**WELWYN HATFIELD BOROUGH COUNCIL
ASSISTANT DIRECTOR (PLANNING)**

Application No: 6/2022/2226/FULL
Location: 20 Black Fan Road Welwyn Garden City AL7 1QA
Proposal: Installation of a "private-wire" electricity cable between the Energy Centre, Tewin Road and Colt Technology Services Group Limited (Option 1).
Officer: Mr Raymond Lee

Recommendation: Granted

Drawing Number: **Q21062-CRP-01** Version: **5.0**

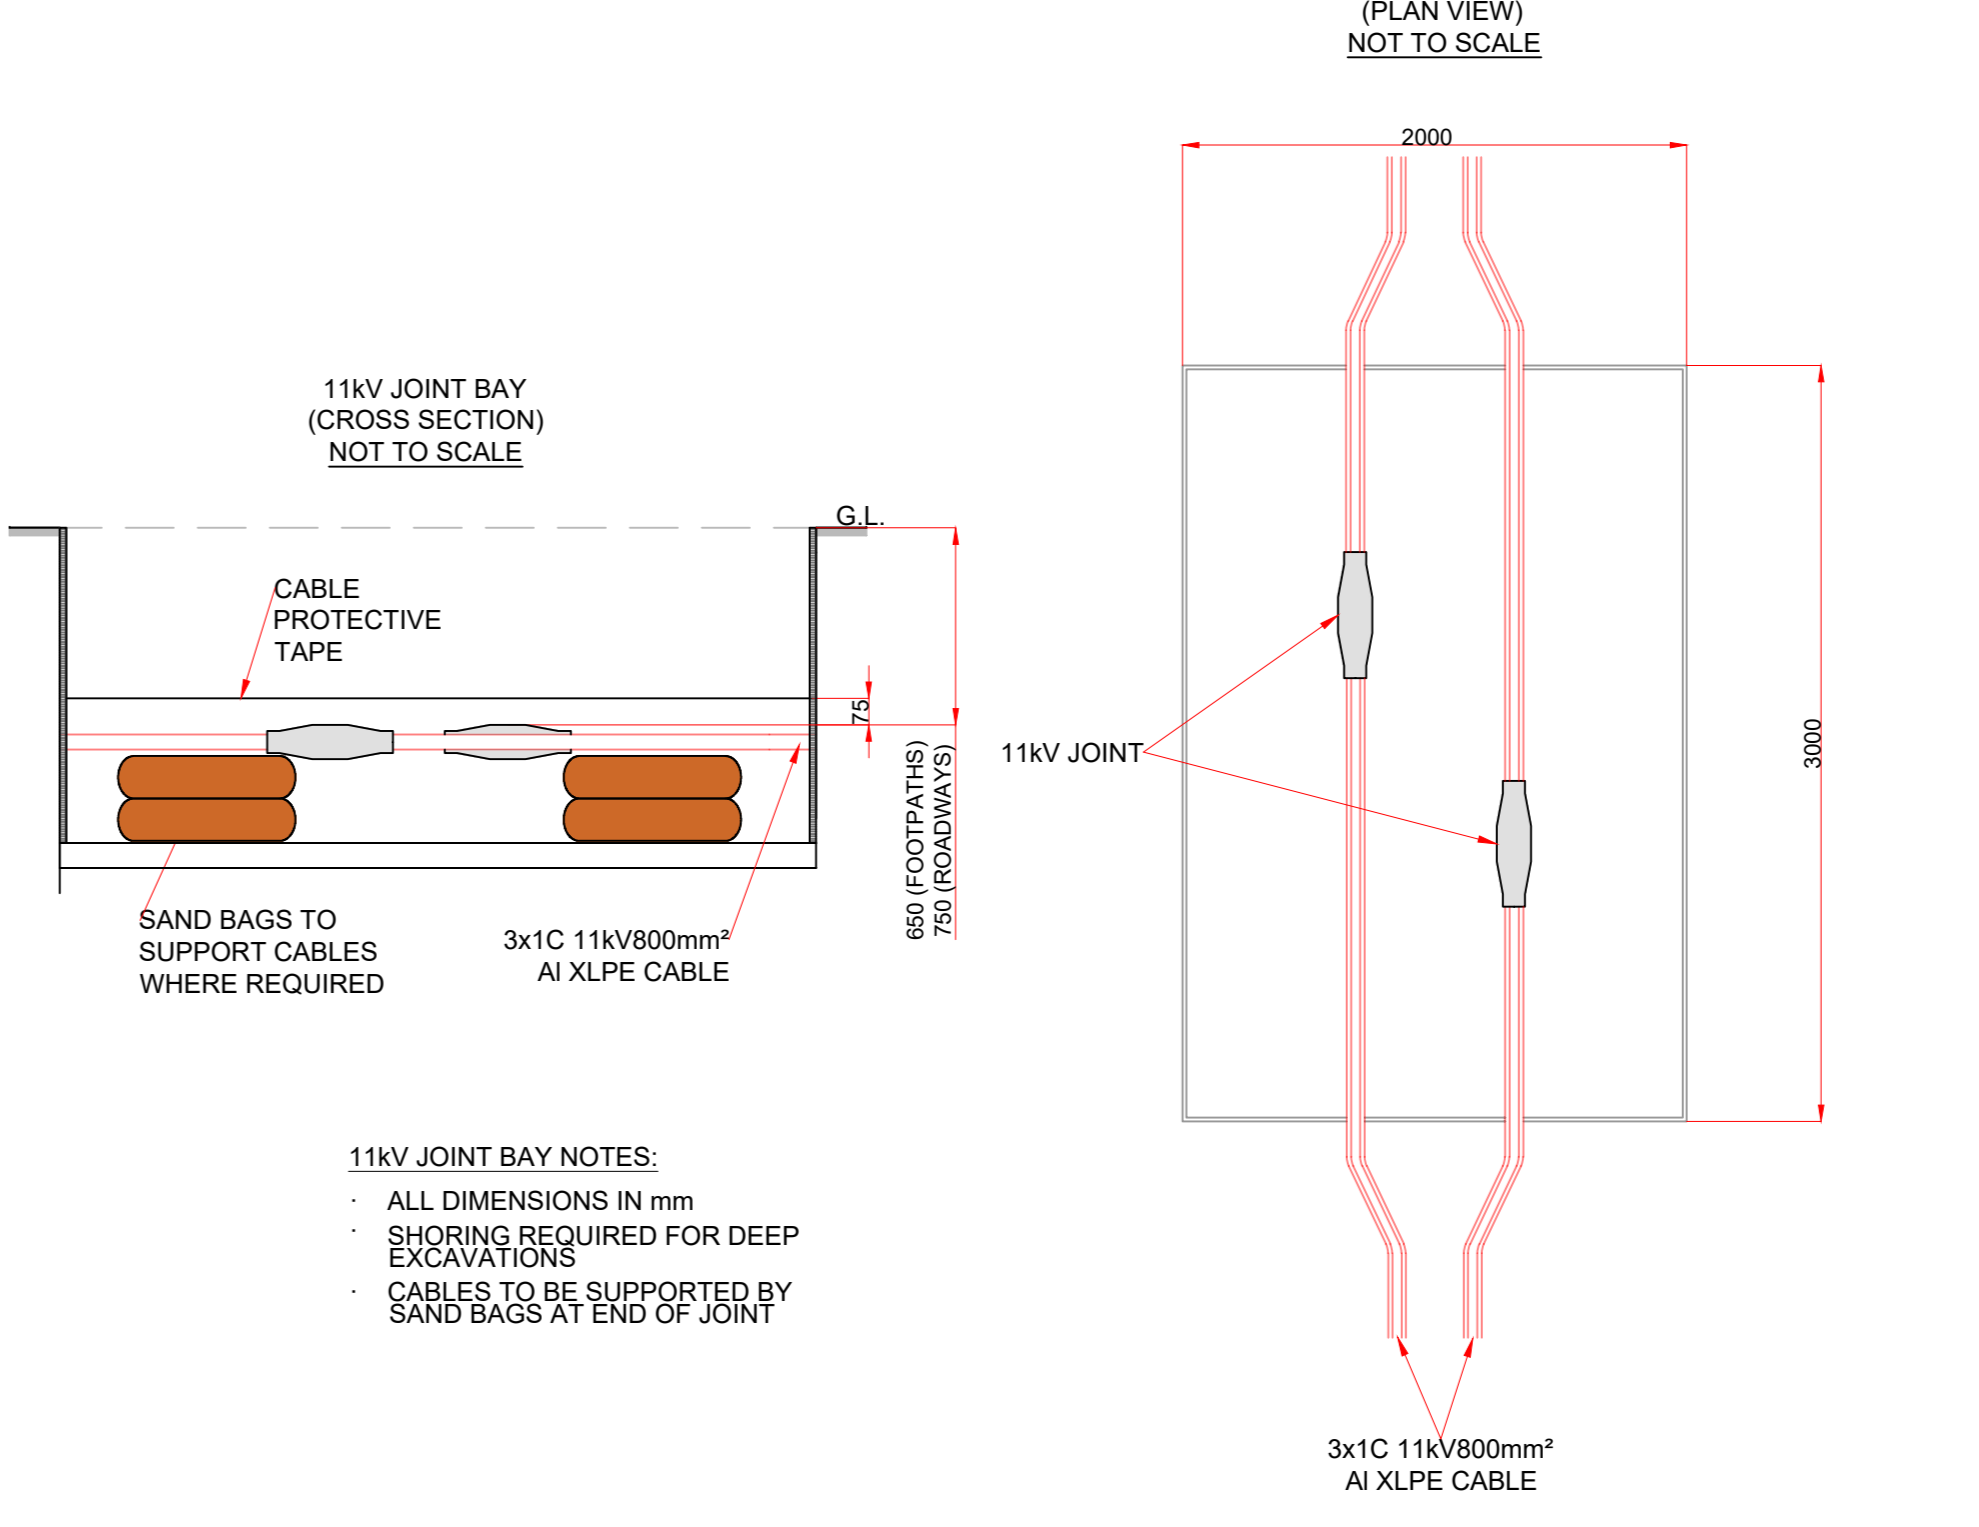
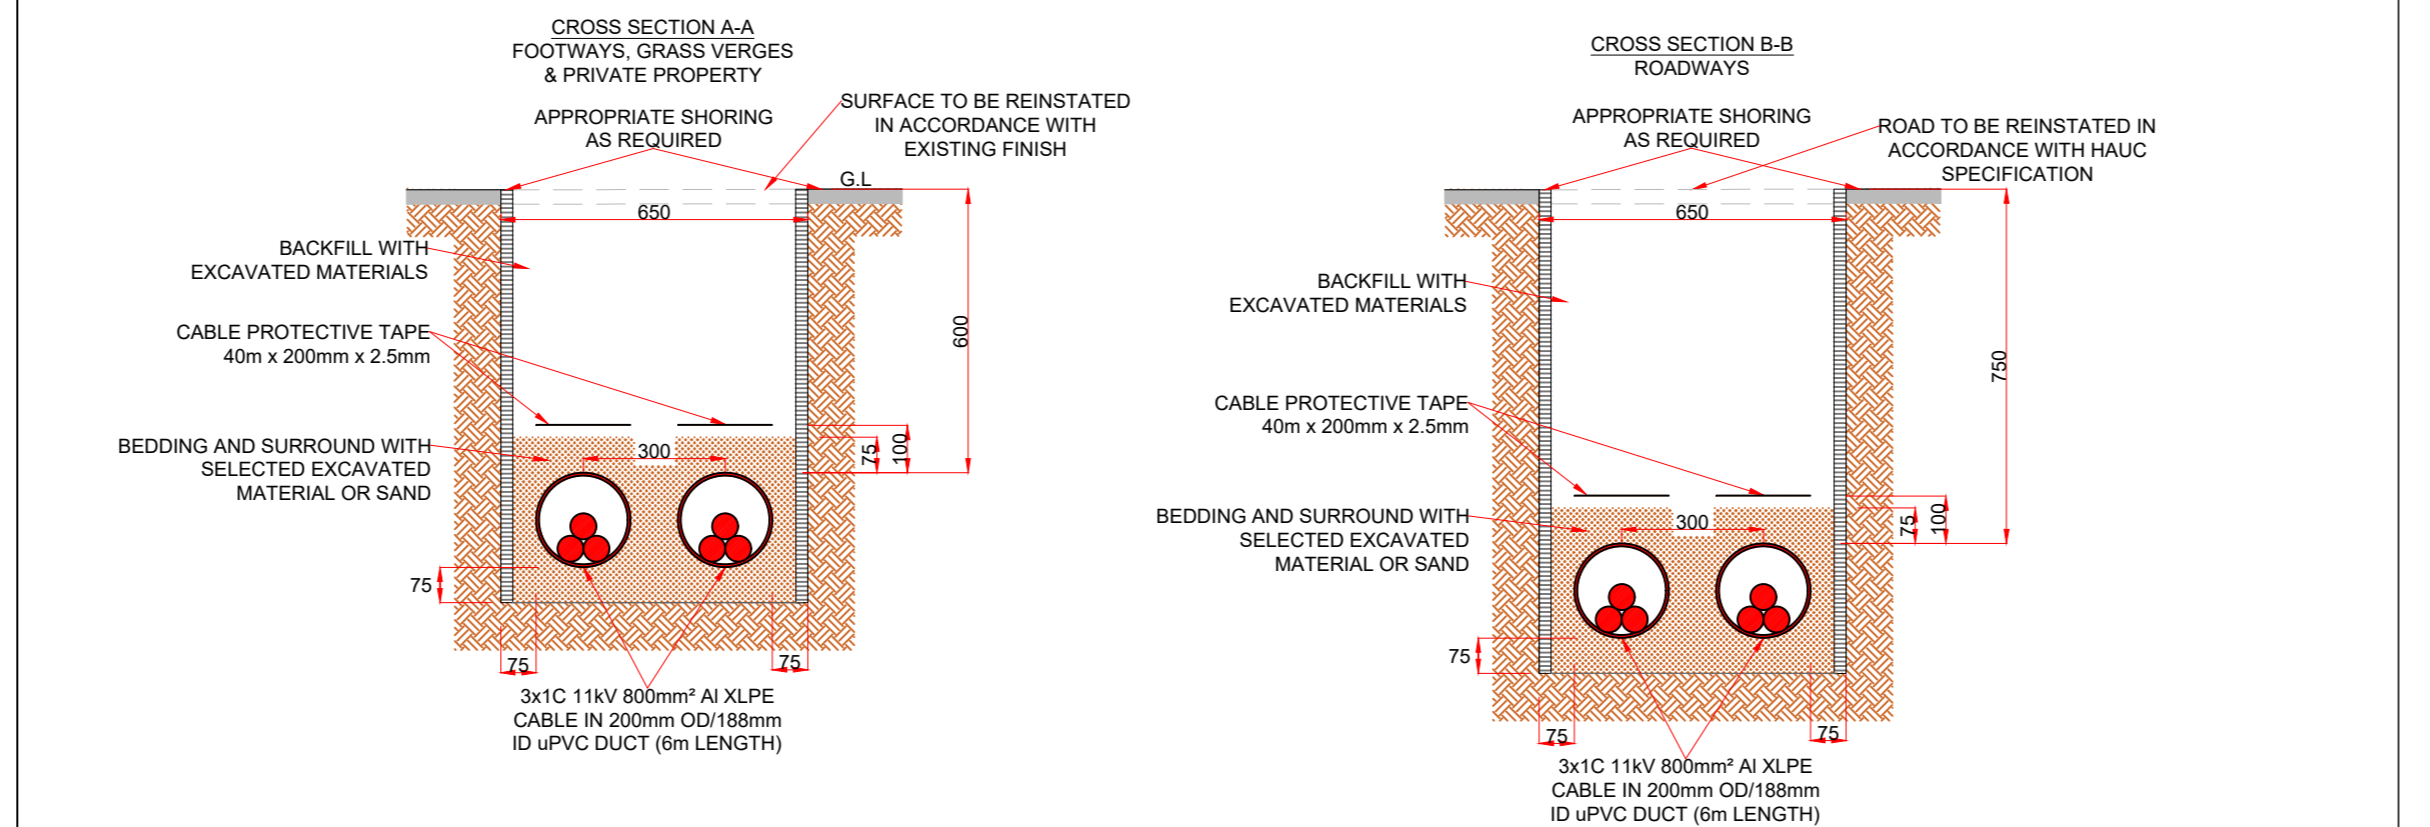
The route of the cable is shown to pass through areas of hardstanding/road verges along Tewin Road, Bridge Road East, Knella Road and Pollards Close. This route then runs through a section of Hem's Wood and through a secondary woodland across Watchmead Local Wildlife Site before eventually reaching the destination site at 20 Black Fan Road. The general character of the area is a mixture of industrial and residential. The development is wholly underground therefore would involve minimal external impact to the site and locality with the only visible part being the covering for the joint bays, which will also be reinstated as per the existing surface finish. Following completion of the duct and cable installation, it is proposed that the surface material will be backfilled to provide a level surface. Provided that the verge, pavement, roads and green areas that would be disturbed by the proposal are restored on completion of the works, it is considered that the proposal would not have a significant impact upon the surrounding area. It is therefore reasonable and appropriate that a condition be imposed to ensure that the land is restored to its former state.

The proposal does not include any cutting or felling of any trees. It is however noted that there are a number of trees located adjacent to the proposed cable route. The submission includes a method of working around the affected trees to avoid damage to tree roots. In this case, the Council's Landscaping Department was consulted and no objections have been raised to the proposed Tree Protection methods contained within the submitted Planning Statement.

1. Within 1 month of the completion of the development hereby approved, the surface of the land where the cable is laid shall be restored to its former condition.

Plan Number	Revision Number	Details	Received Date
Q21062-CRP-01	5	Location plan and proposed route of cable	21 November 2022
